**WELWYN HATFIELD BOROUGH COUNCIL
EXECUTIVE DIRECTOR - PLANNING, PUBLIC PROTECTION AND GOVERNANCE**

Application No: 6/2020/1837/FULL
Location: 54 Bridge Road Welwyn Garden City AL8 6UR
Proposal: Erection of new detached dwellinghouse to the rear garden.
Officer: Mr Raymond Lee

Recommendation: Refused

Drawing Number:
IND-754-P20

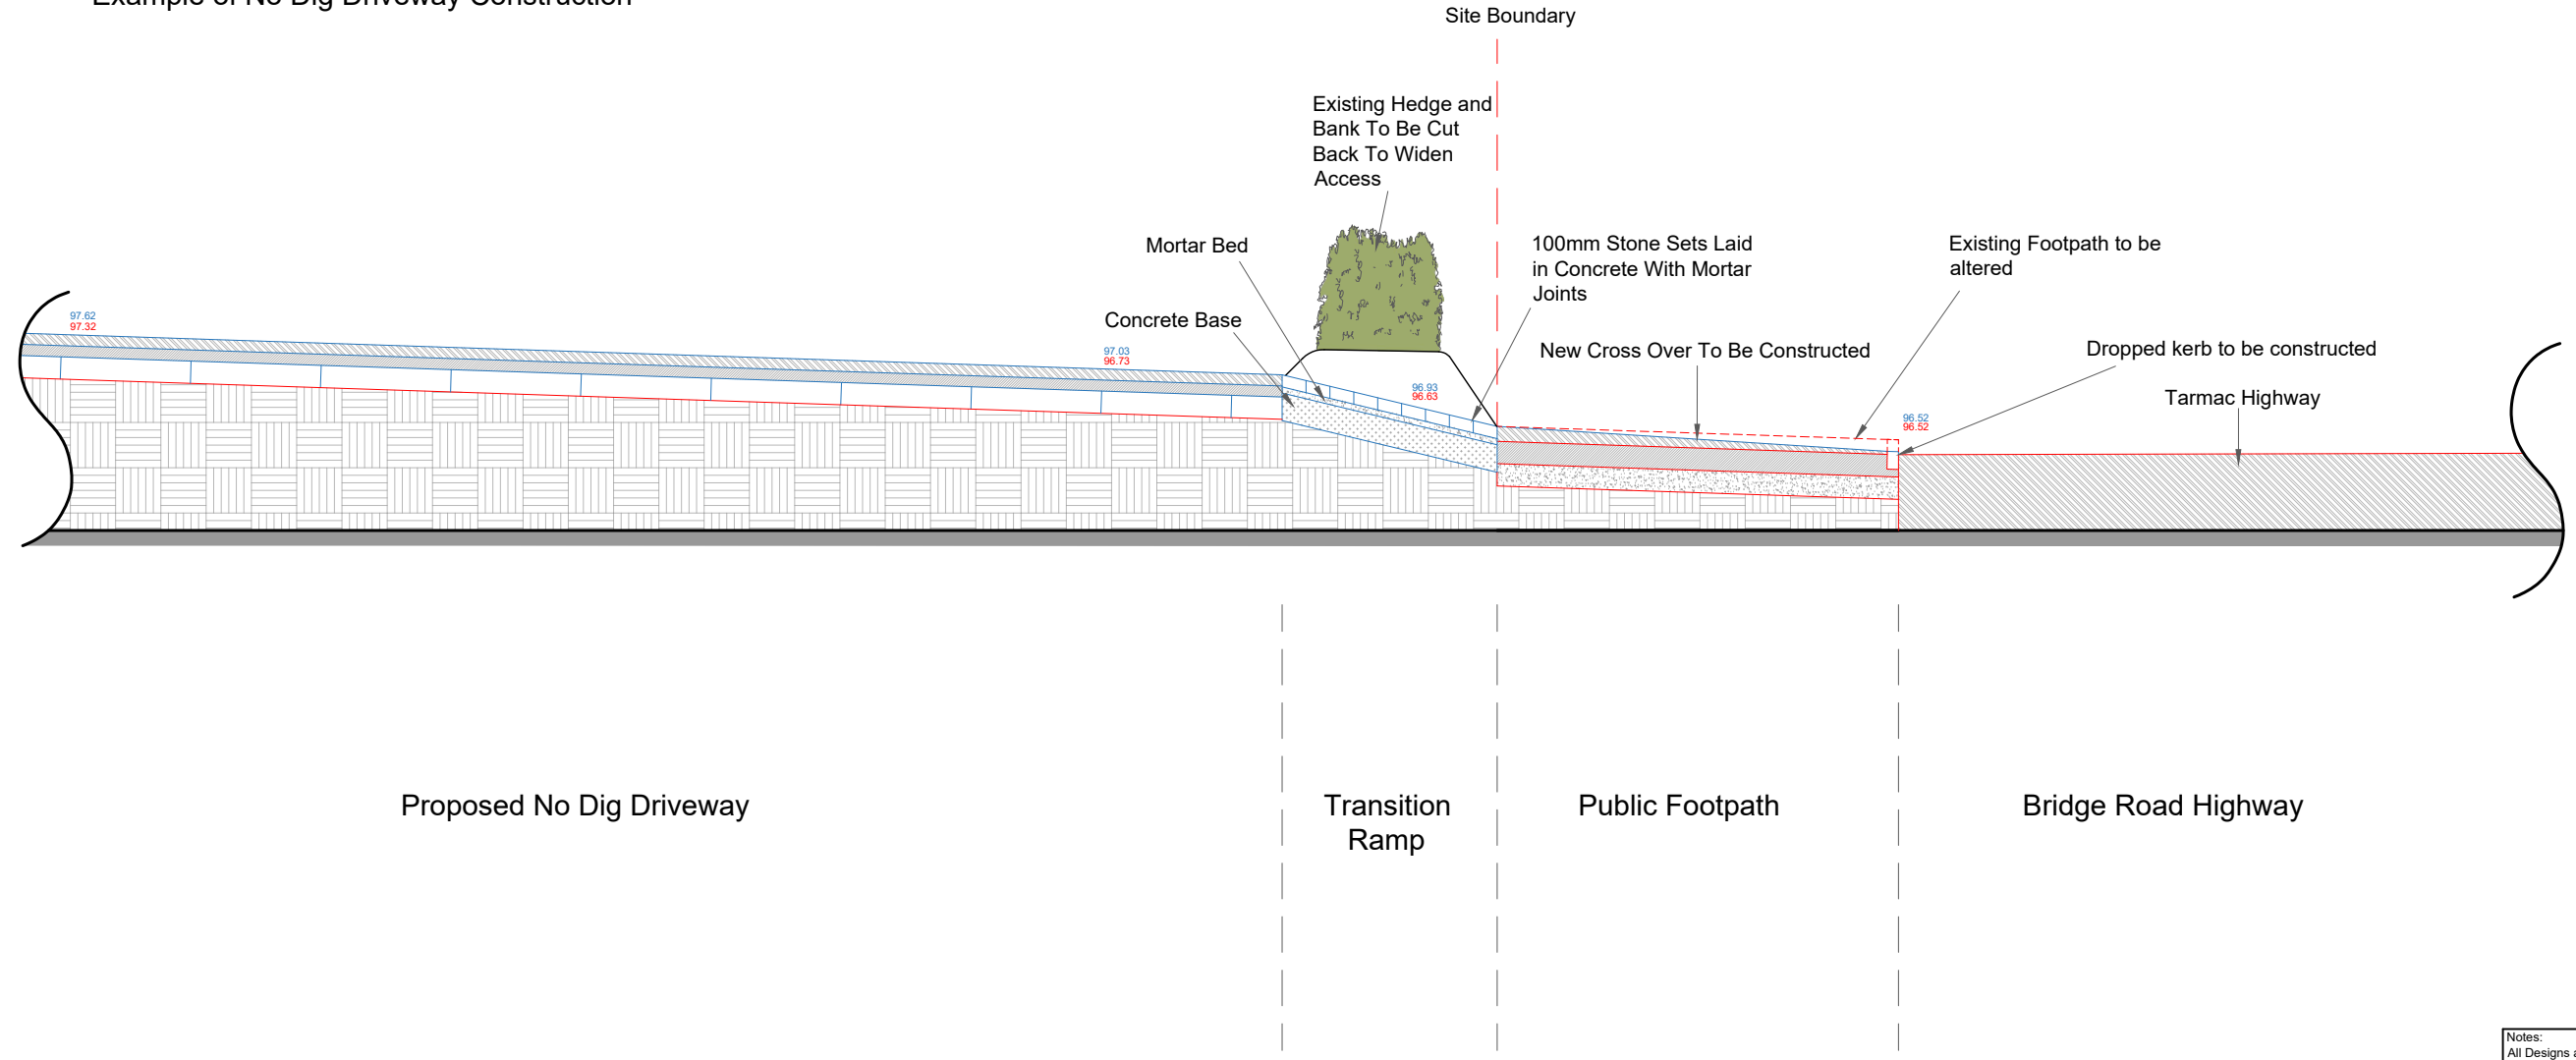
Turning to the impact upon the Conservation area, while the proposed dwelling is relatively well screened from Bridge Road due to its position towards the rear of the plot, the Conservation Officer states that the loss of part of the hedgerow for the creation of the driveway has a negative impact on the streetscene by undermining its verdant character, which is typical of the Garden City. On this basis, there would be 'less than substantial' harm to the Conservation Area and as per paragraph 196 of the NPPF, this harm must be weighed against the public benefits of the proposal.

N6/2014/2504/FP and this application will affect the RPA of T1. The applicant has supplied a Arboricultural Impact Plan which goes some way to minimising the impact on the on T1, but further detailed would be required to ensure the tree is retained successfully. If approved a detailed Arboricultural Method Statement (AMS) would be required as a condition prior to any on site activity. The AMS should not only look at the construction of the access but also storage of building materials and working methods on site.
